H09-0287-24 - Section 73 Application

Residential Development 188 Dwellings, Damgate, Holbeach.

Amended Information to planning services 24.06.2024

Details of amendments

Drawing: BOUNDARY TREATMENT PLAN (INCLUDING NEST BOX LOCATIONS)

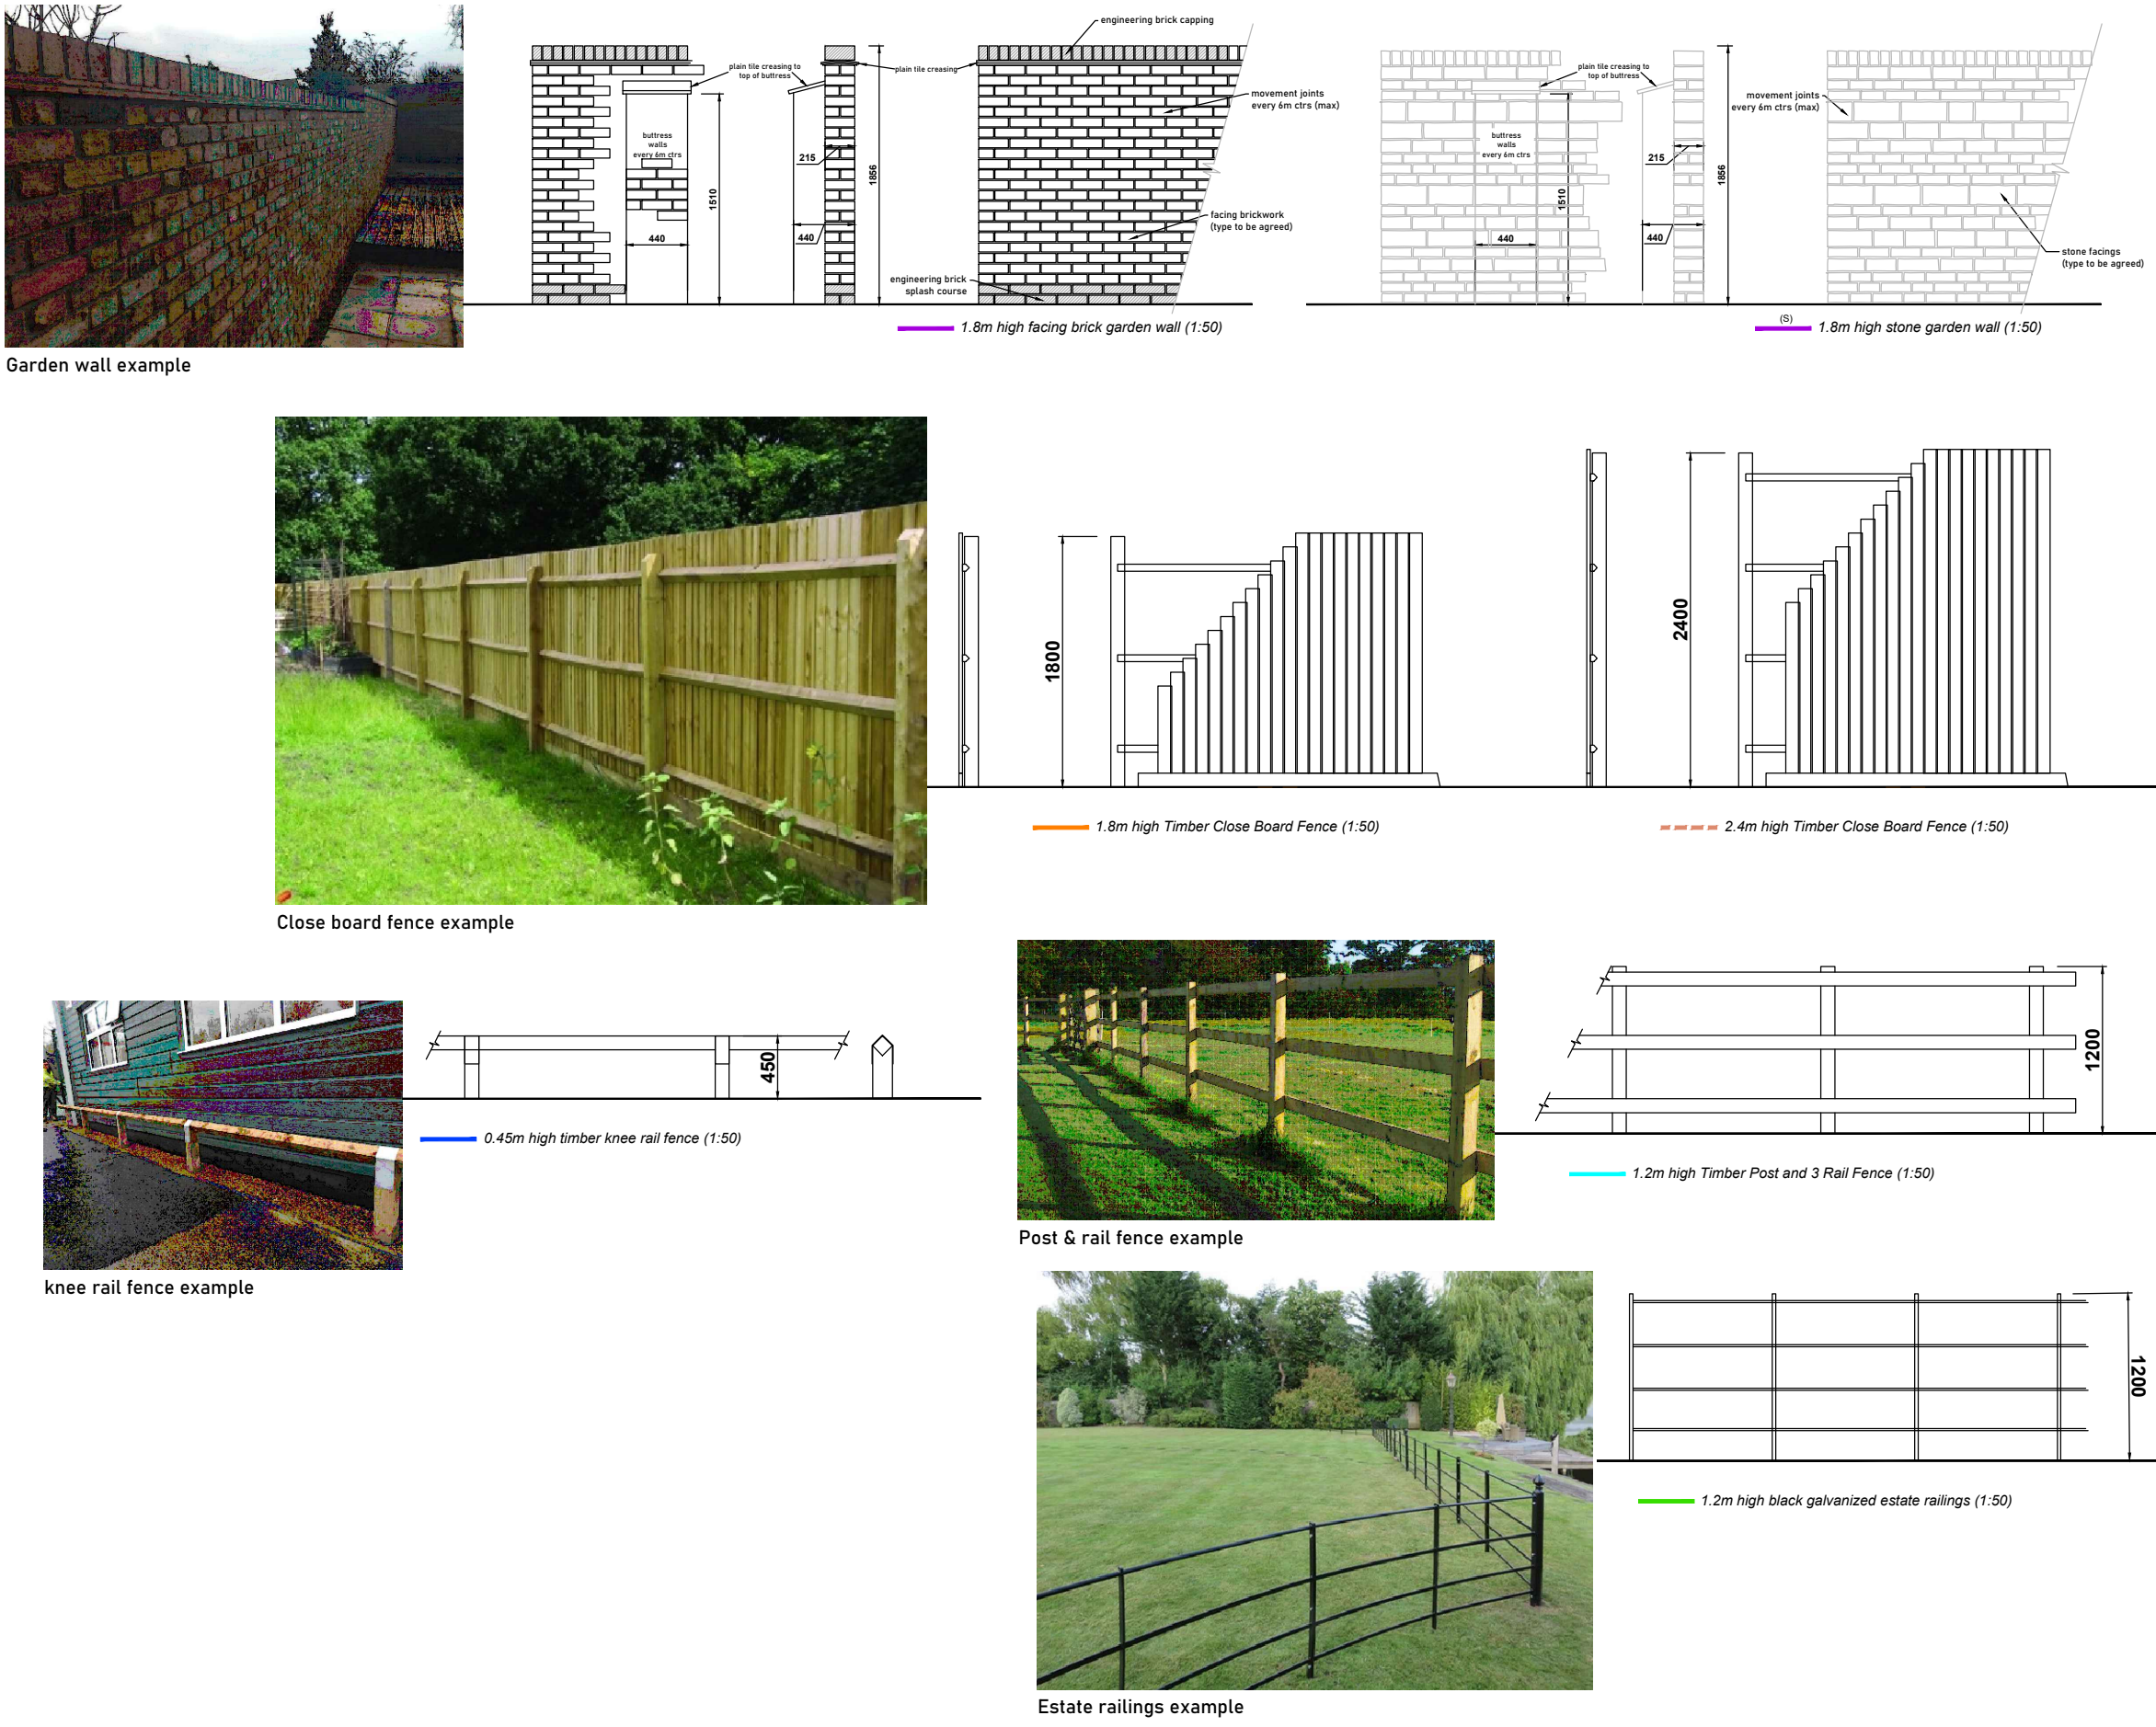
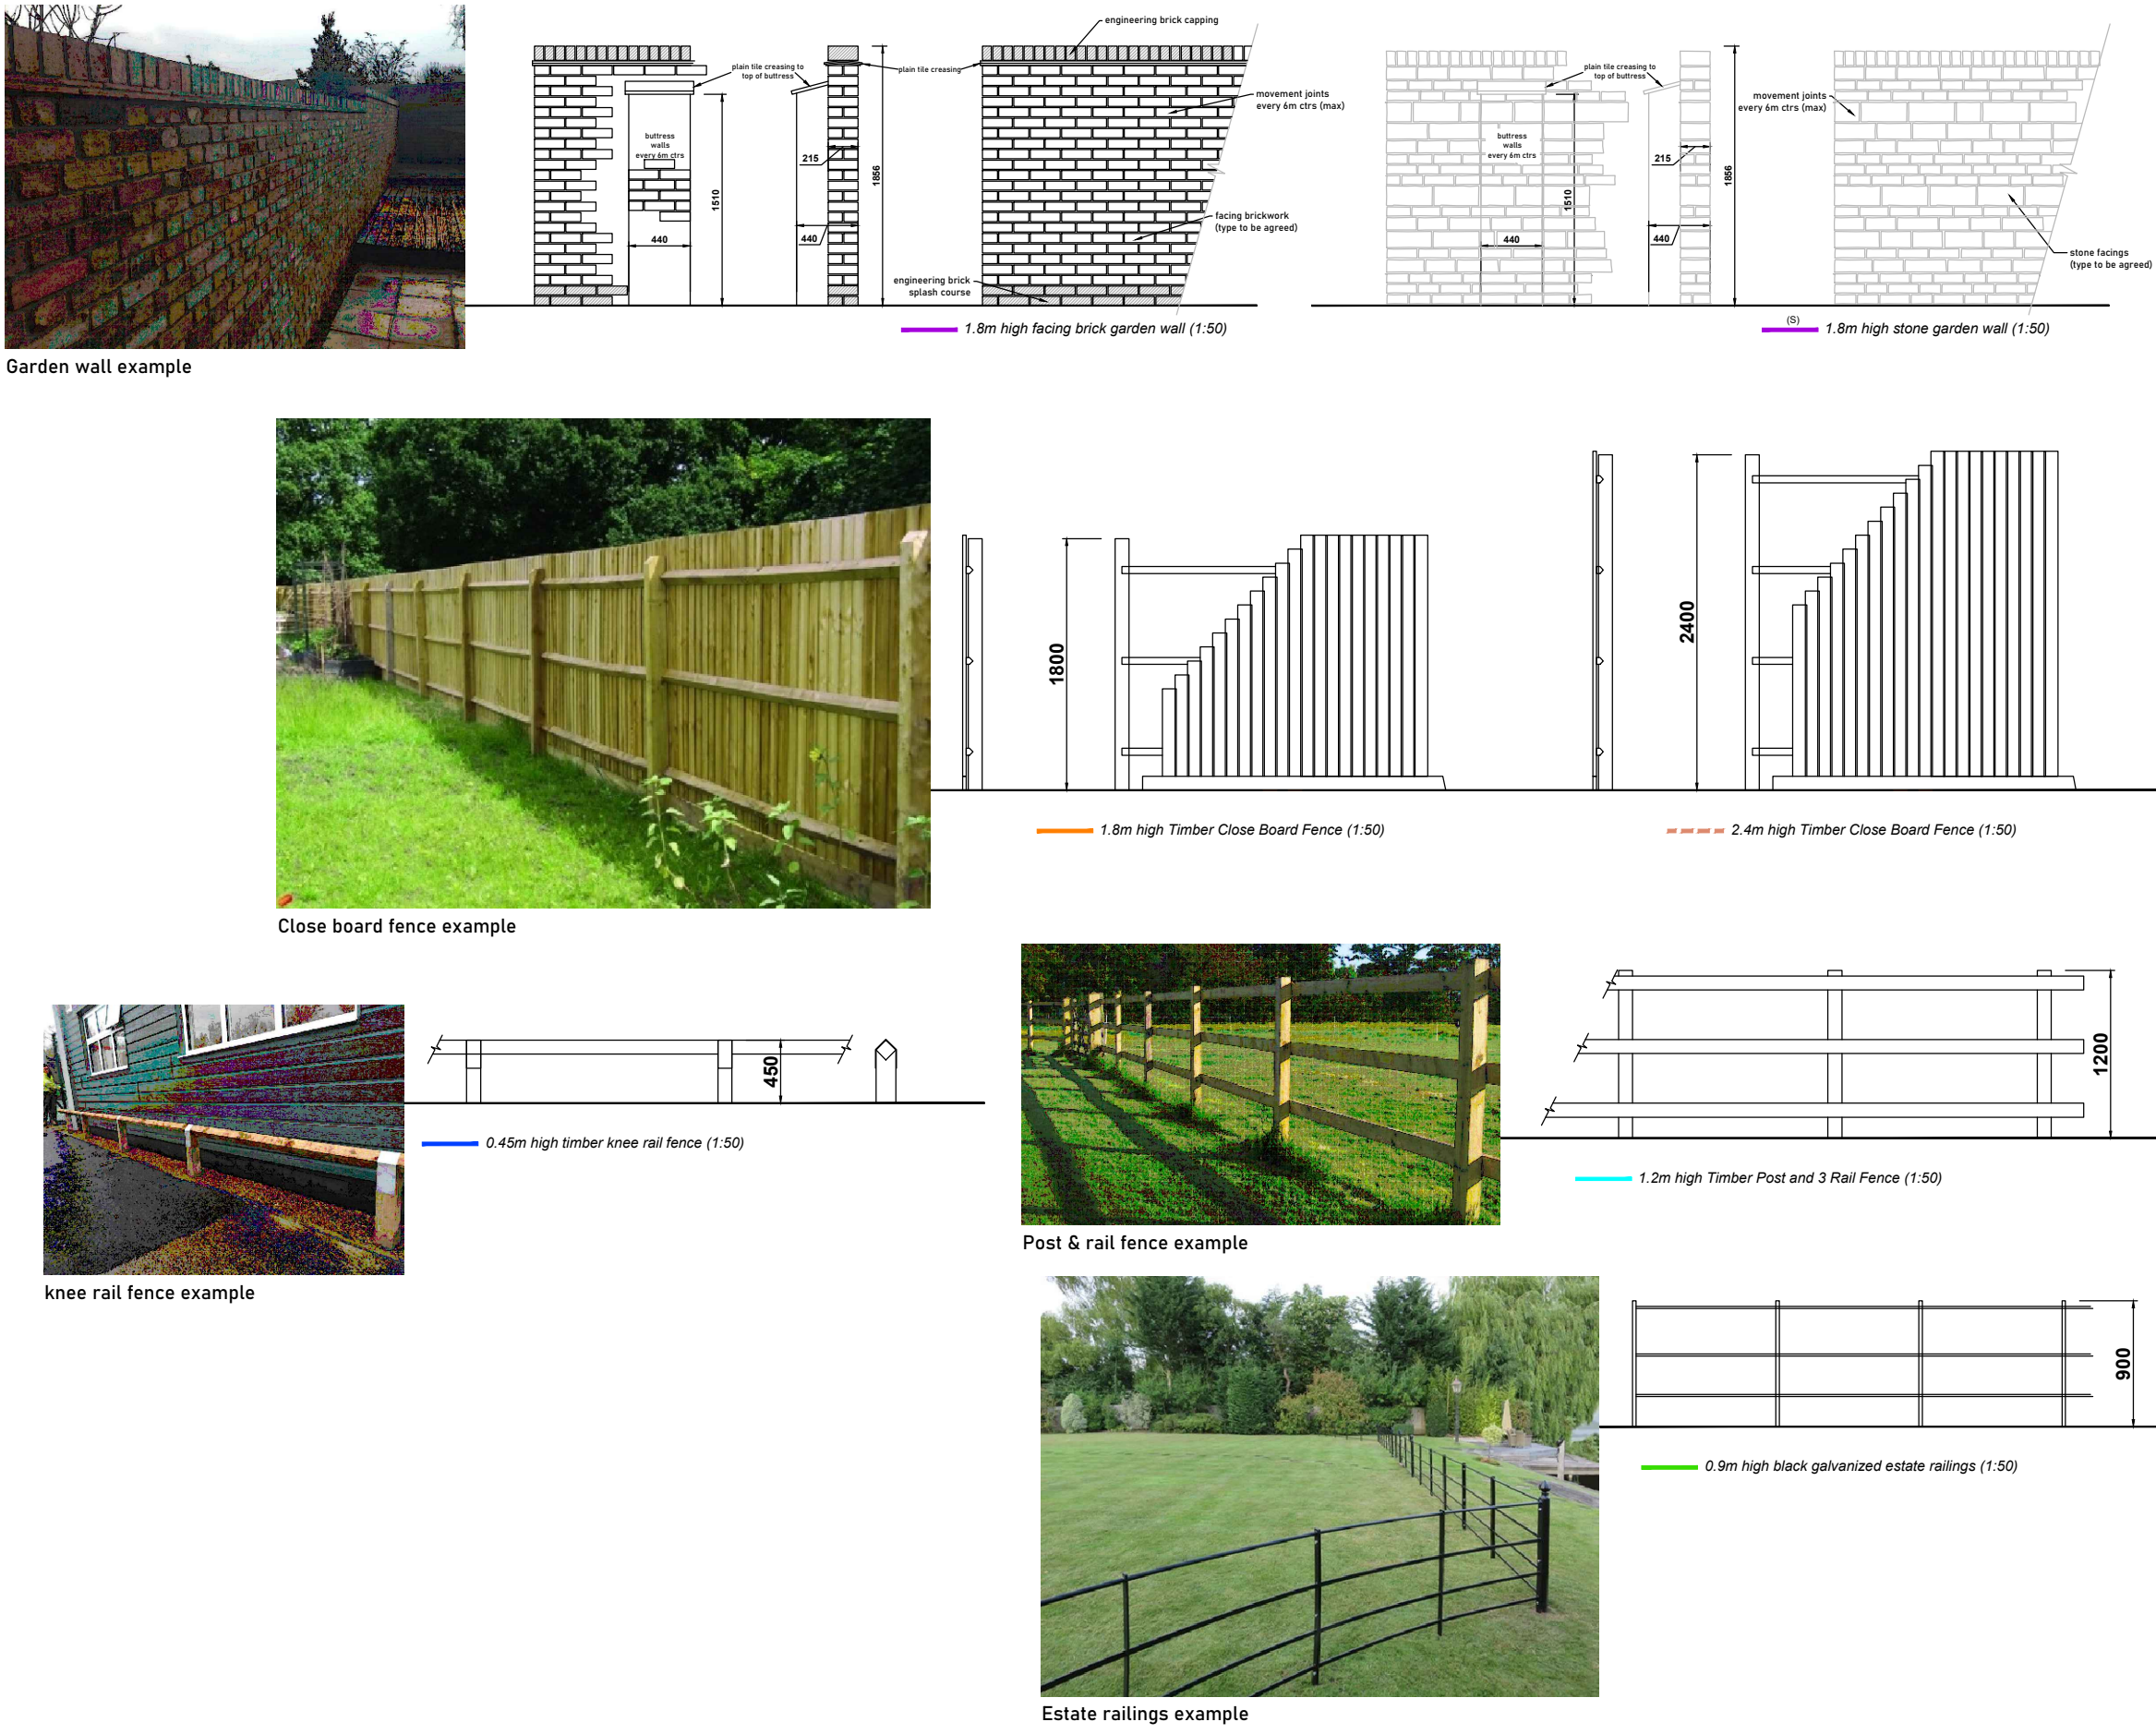
- Roof pitch to plot 188 garage reduced.
- Windows incorporated to first floor elevation of Chatswoth House type facing Damgate.
- Side window incorporated to Belton House type .
- Garage to plot 8 revised to a double garage and single garage now introduced to plot 9
- House type to plot 9 repositioned.
- Driveways and boundaries updated to suit changes
